Your Ref: OWPC25377
Our Ref: R/270/19/HH 20-11-2019
Please ask for:
Zac Denton

Ground and first floor rear extensions - resubmission of R/197/18/HH
1 Pigeonhouse Lane Rustington

Thank you for your internet representation made on 2nd January 2020 which has been recorded as '**an objection**' with the comments as follow s:

Drawing Title: PROPOSED ELEVATIONS

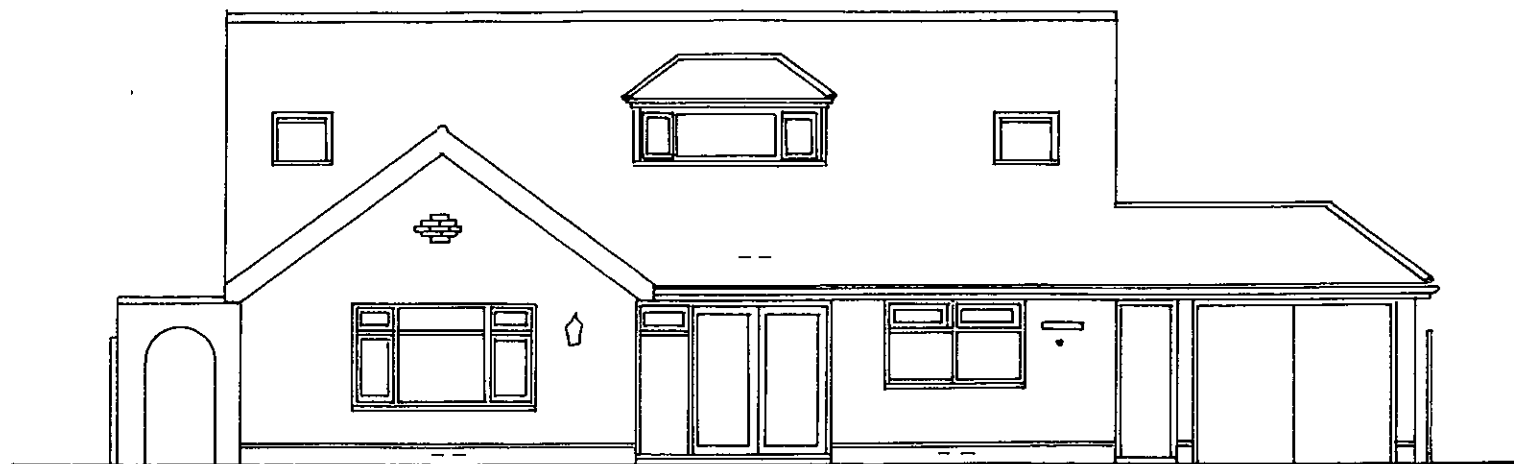
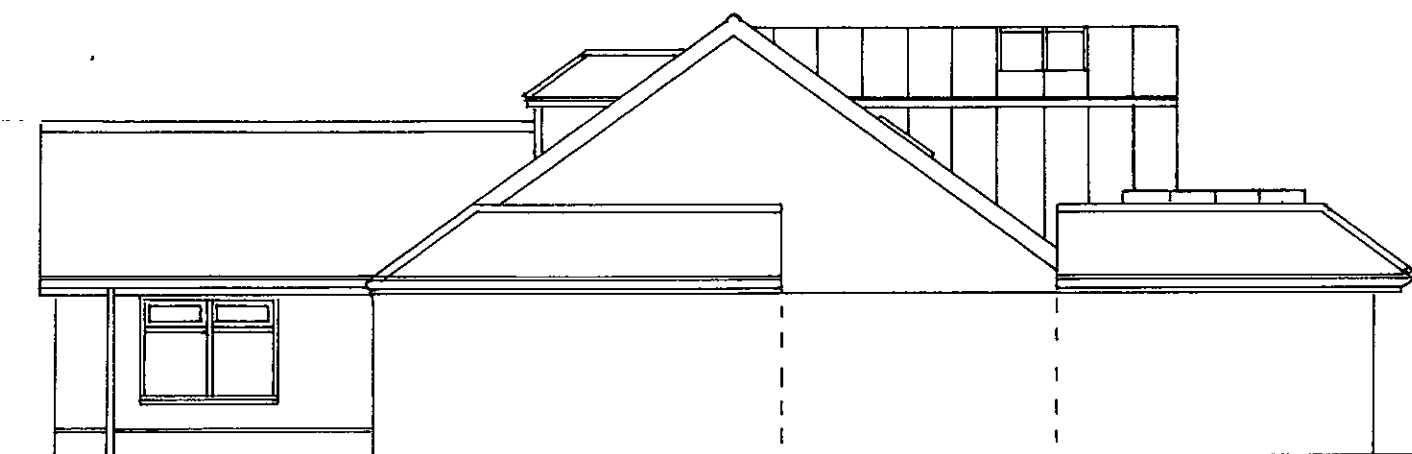
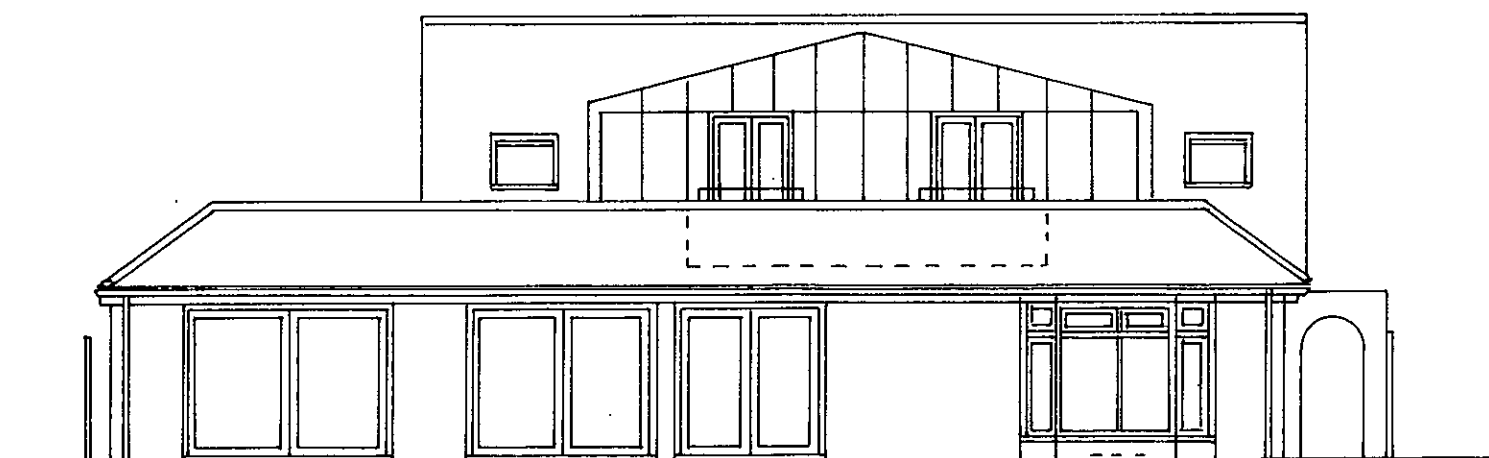
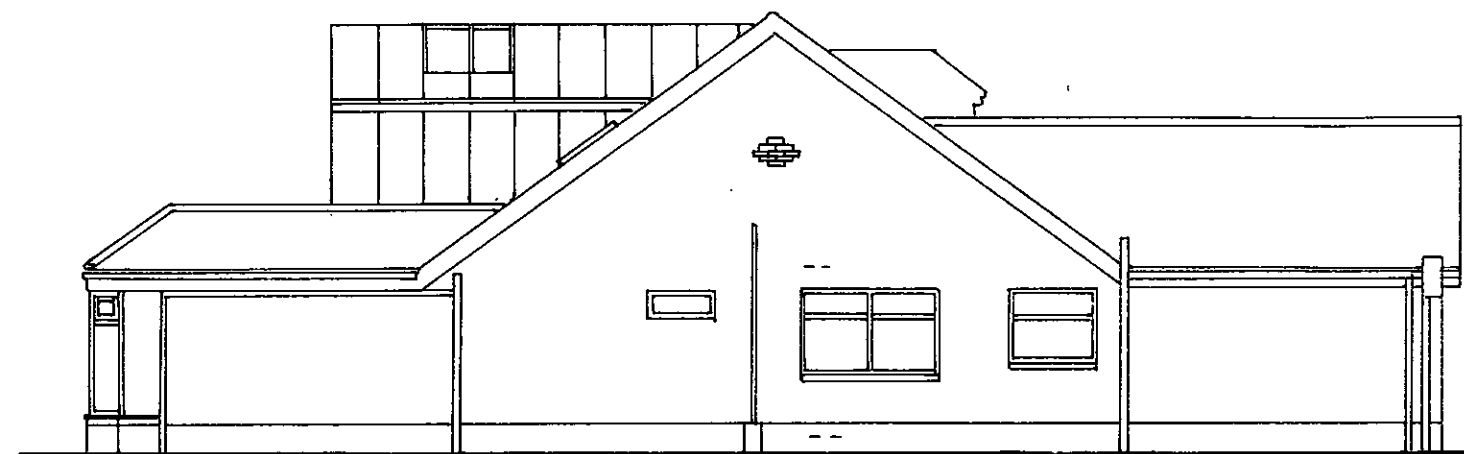
The proposed development is overbearing upon neighbouring occupiers both to the north and the south by virtue of the scale and massing. It is bulky and unattractive with a zinc roof/cladding totally out of keeping with the area. It will completely dwarf the property to the south and overshadow that to the north by virtue of extension to the full height of the ridge of the existing building. Such scale and massing will clearly have an unacceptable incongruous impact upon the character and appearance of the host bungalow, which has already been extensively extended. It is an overdevelopment of a small site and conflicts with D DM1 and D DM4 of the Arun Local Plan and policy 2 of the Rustington Neighbourhood Plan as it is not at all sympathetic to, nor in any way reflective of, the architectural style and character of the host bungalow nor its locality.

The proposed French doors and roof terrace will clearly intrude even more upon neighbouring occupier's enjoyment of their gardens than the previously refused proposals. The amenity of enjoying the late afternoon/evening Summer sun necessitates our sitting at the eastern end of our gardens which will intrusively be overlooked, as will the living space of 7 Cross Road.
